From:
Sent: 26 March 2026 08:19
To: DC Admin
Subject: Application 2026/44/90509/E – Comment on discharge of Condition 3

I would like to comment on the application to discharge Condition 3 for Firths Yard, Mill Road, Dewsbury.

DRAWING TITLE
Drainage Layout & Details

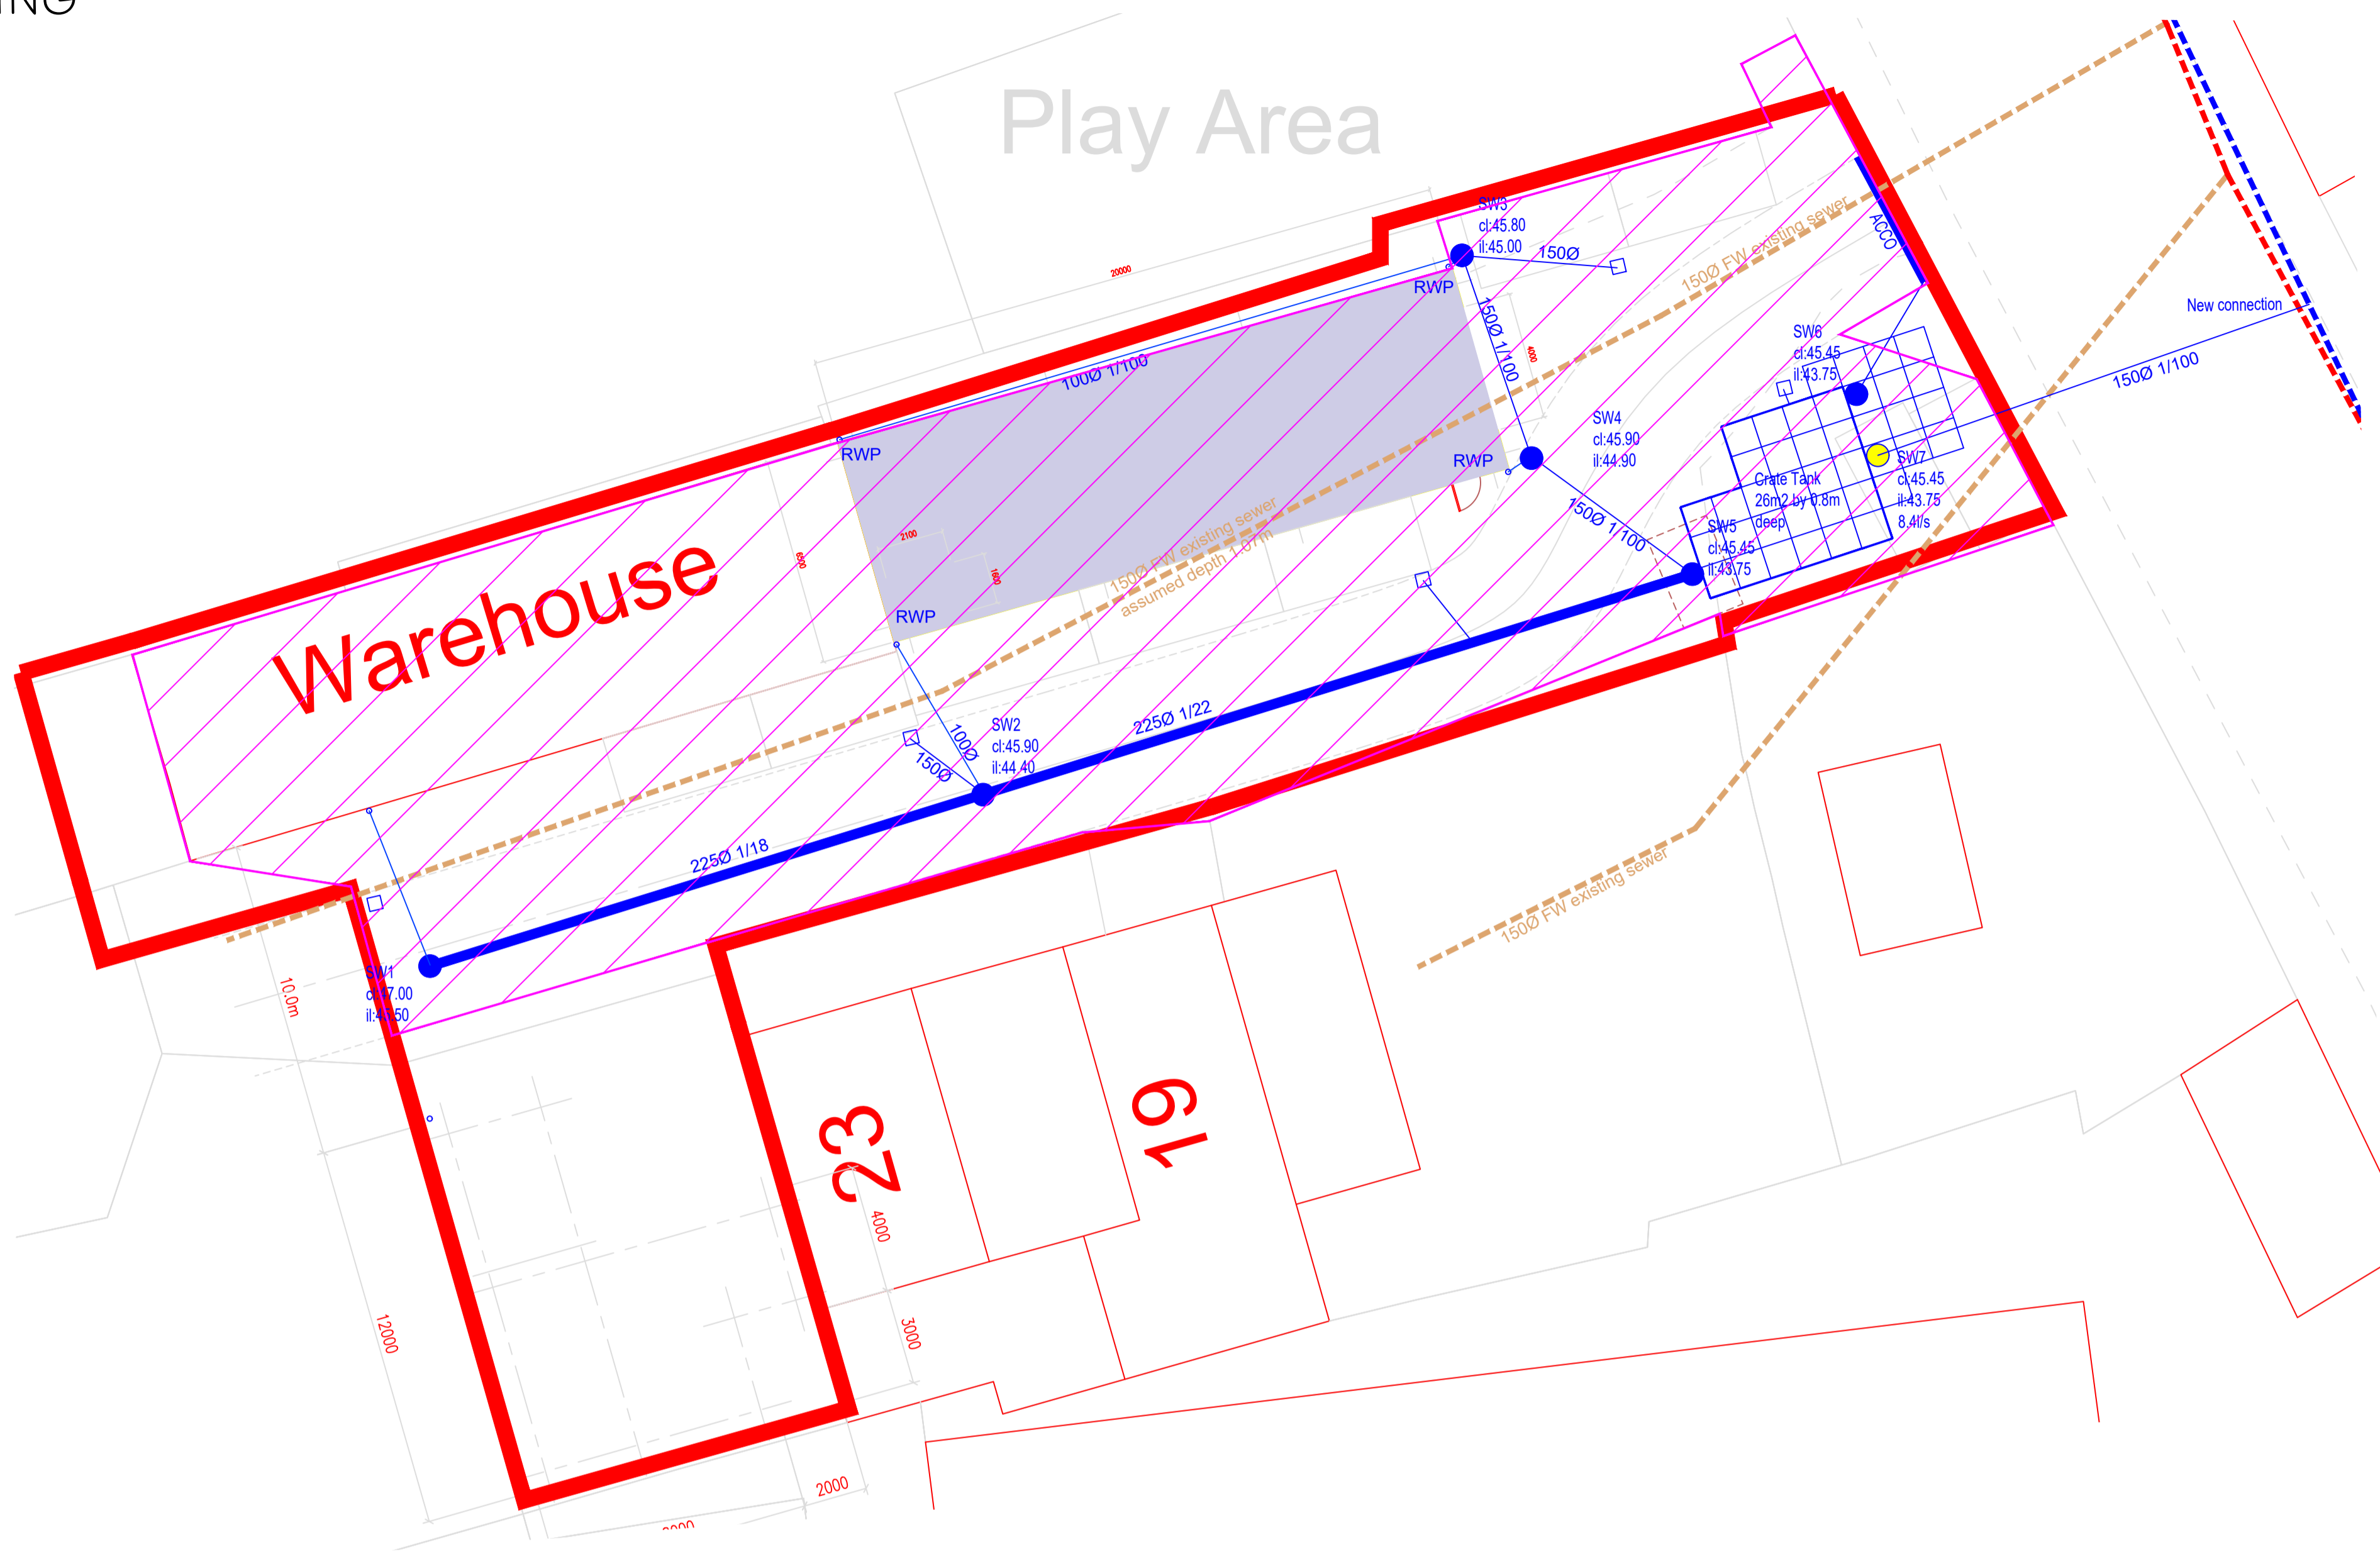
The drainage proposals appear to rely on existing foul sewer infrastructure which serves our property. No details have been provided explaining how these existing sewer pipes will be protected or accommodated during construction. The submission also does not address other known service media within the site including gas pipe infrastructure, private water pipes and electric cables serving neighbouring land. As these services are required for the continued operation of adjoining property, it is unclear how the drainage scheme can be implemented without affecting existing connections.

There also appears to be insufficient information provided in relation to Unit 1 and how the proposed drainage and layout arrangements interact with existing services serving that unit.

The plans do not clearly show the proposed surfacing levels or specification across the site, despite the condition specifically requiring details of surfacing. It is therefore unclear whether the finished levels and gradients will allow safe and practical vehicle and pedestrian movement.

In addition, the submitted details do not clearly show pedestrian access arrangements as part of the layout. As Condition 3 requires details of layout and access in the interests of highway safety, it is unclear whether safe and suitable access has been demonstrated.

Given the proposed Class E / B8 use, clarification should also be provided confirming that sufficient turning space and manoeuvring areas remain achievable as shown in the approved planning drawings. It is not evident from the submission that servicing and vehicle movements can be accommodated safely once drainage constraints and existing service infrastructure are taken into account.
